City of Portland, Maine – Building or Use Permit Application, 389 Congress Street, 04101, Tel: (207) 874-8703, FAX: 874-8716

Location of Construction: 208-210 High St (Rear)		Owner: B & G Management Corp		Phone: 829-4752	Permit No: 980700
Owner Address: 18 Hazeltine Dr Cumberland, ME 04021		Lessee/Buyer's Name:		Phone:	BusinessName:
Contractor Name: *** Bruce Meyers		Address: 237 High St Apt B Portland, ME 04101		Phone:	
Past Use: 6-1an	Proposed Use:		COST OF WORK: \$ 5,800.00	PERMIT FEE: \$ 50.00	
			FIRE DEPT. <input checked="" type="checkbox"/> Approved <input type="checkbox"/> Denied	INSPECTION: Use Group: Type:	
Proposed Project Description: Tear down existing decking & replace with PT Decking for means of egress from building Not to exceed existing footprint			Signature: [Signature]		Signature: [Signature]
			PEDESTRIAN ACTIVITIES DISTRICT (P.A.D.) Action: Approved <input type="checkbox"/> Approved with Conditions: <input type="checkbox"/> Denied <input type="checkbox"/>		
Permit Taken By: NG			Date Applied For: 16 19 June 1998

BUILDING PERMIT REPORT

DATE: 6/30/98 ADDRESS: 205-210 High St Rm
REASON FOR PERMIT: rebuild deck
BUILDING OWNER: B+L Mfg. Co.
CONTRACTOR: Bruce Mey

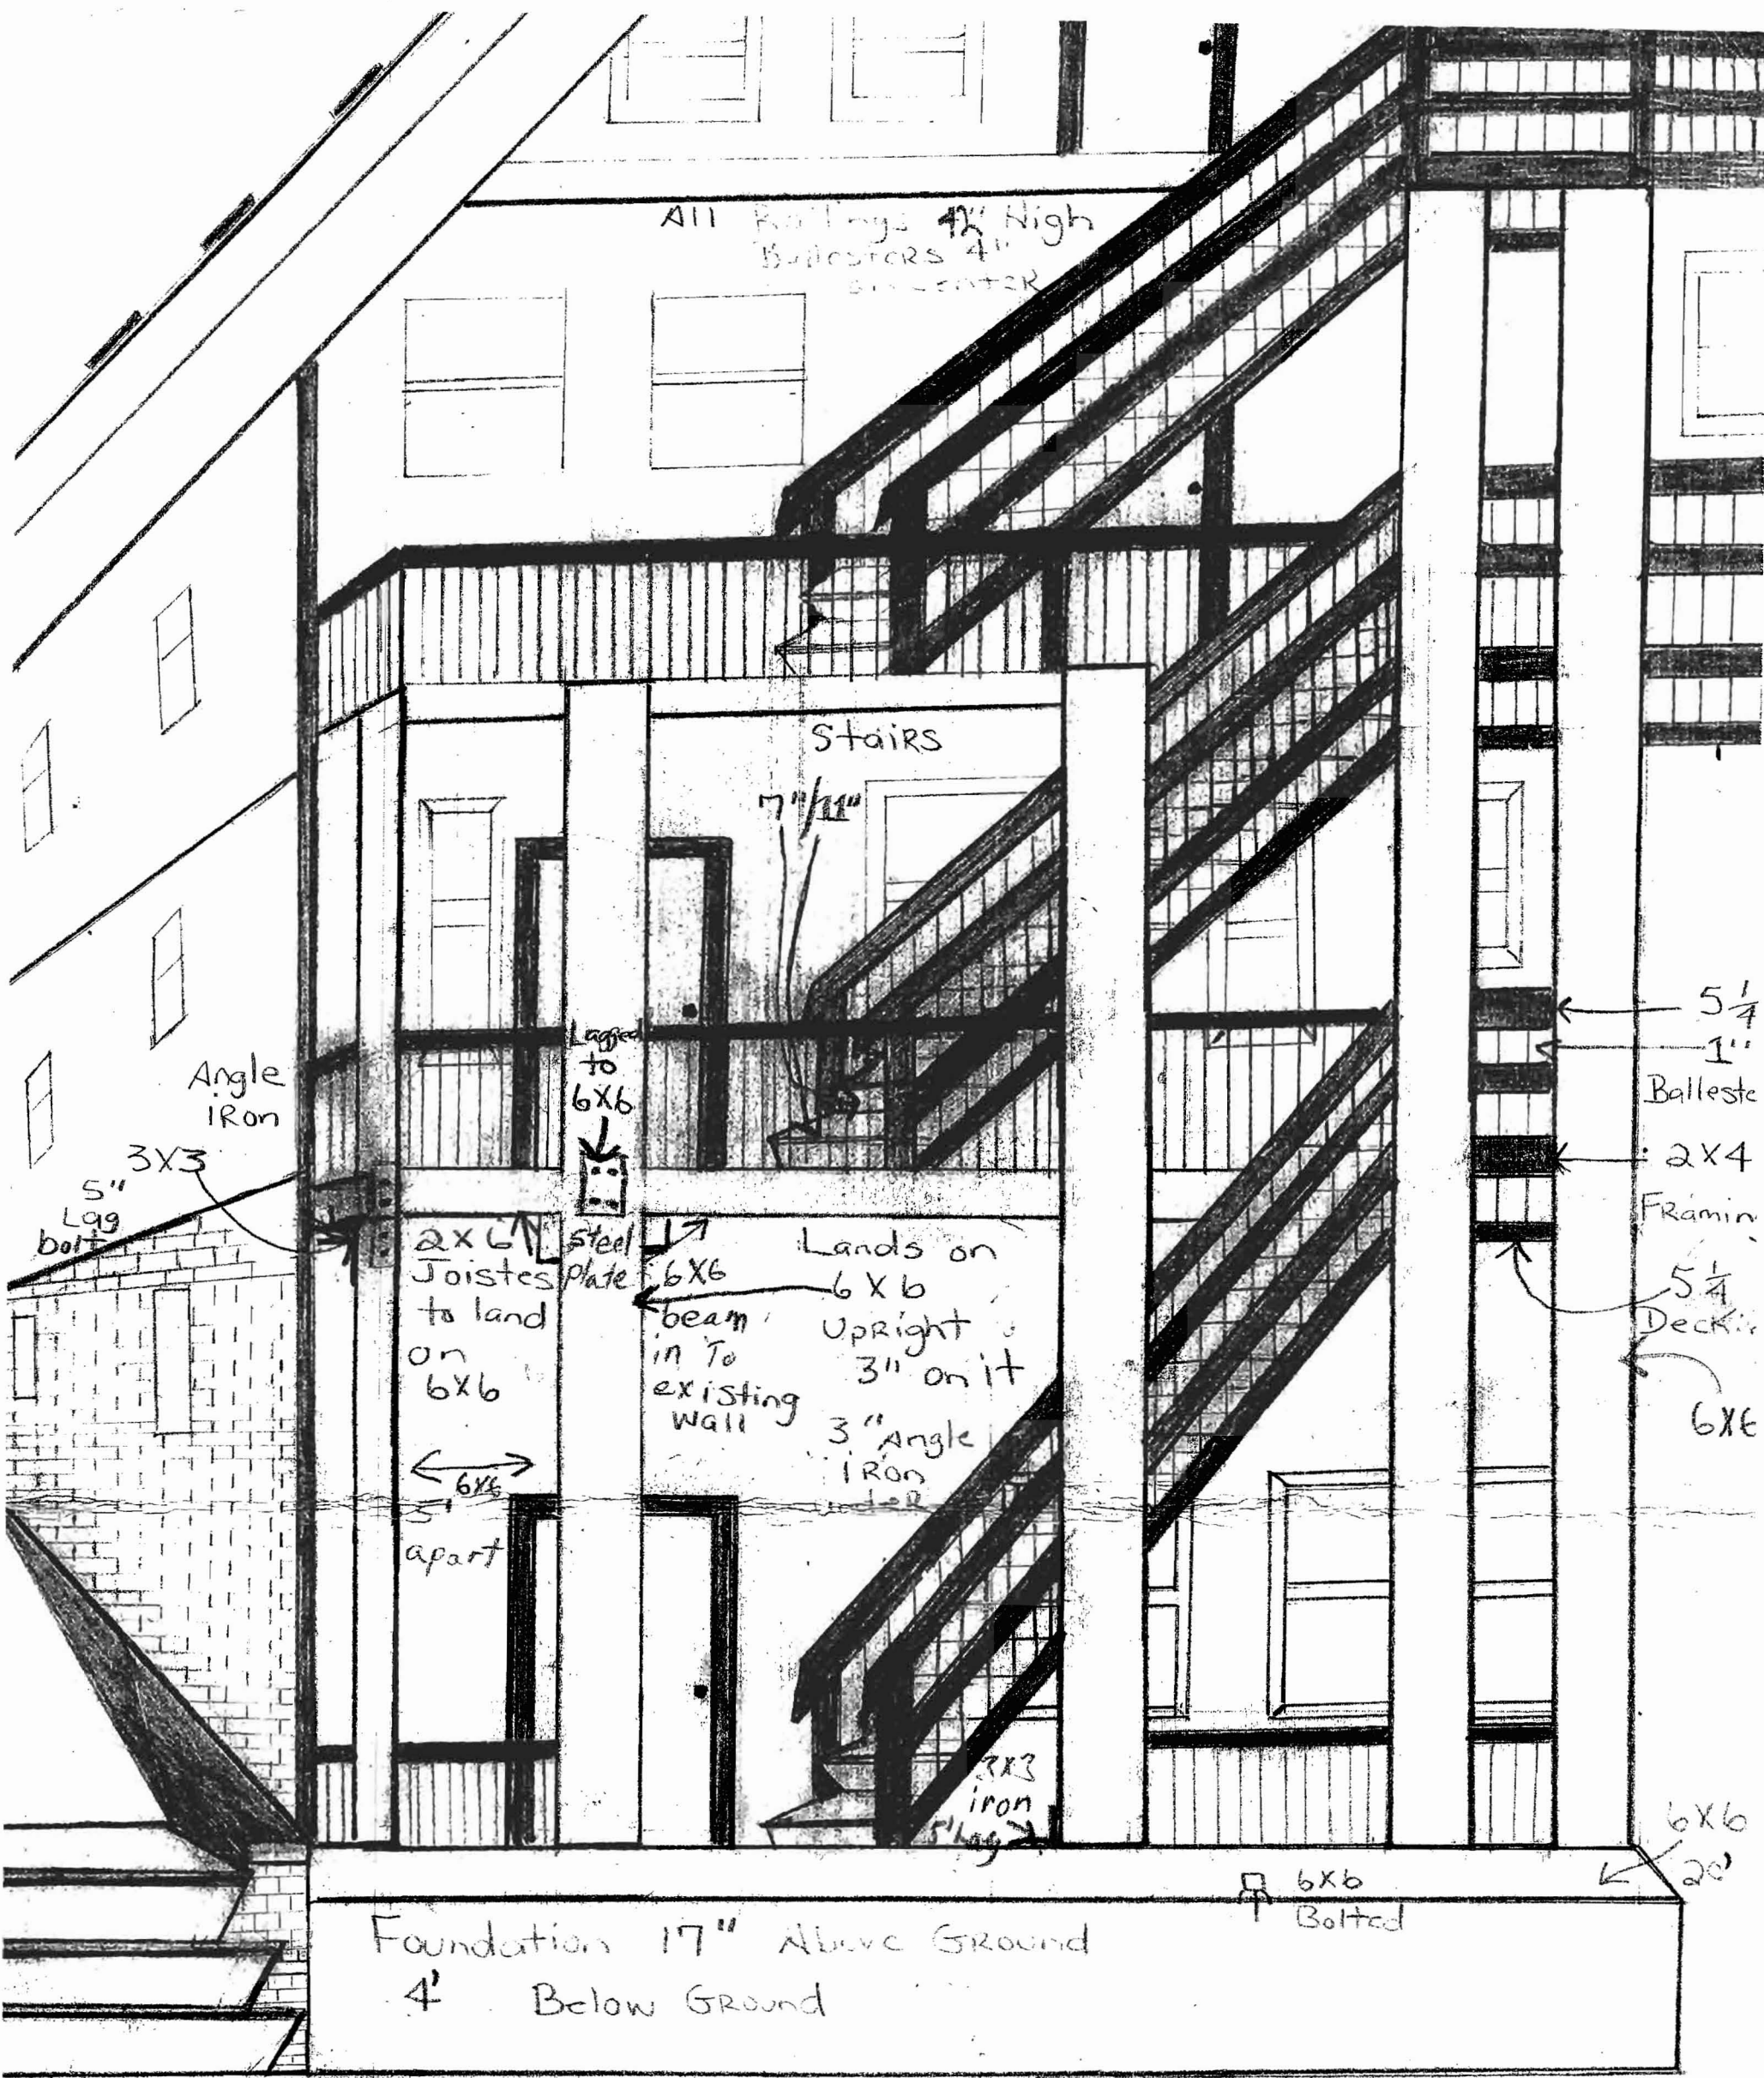
Sam + Mac. will Decide on 9/2/98 we visited the site and the decision was made that Bob Marine will submit a letter and plan stating what is presently there and acknowledge that when the stairs are replaced they will have to meet the 7" Rise and 11" Tread Rule (TER)

30. *Handrails shall be graspable 1 1/2" - 2" in diameter.*

- X 31. *Proposed deck NOT to exceed existing footprint.*
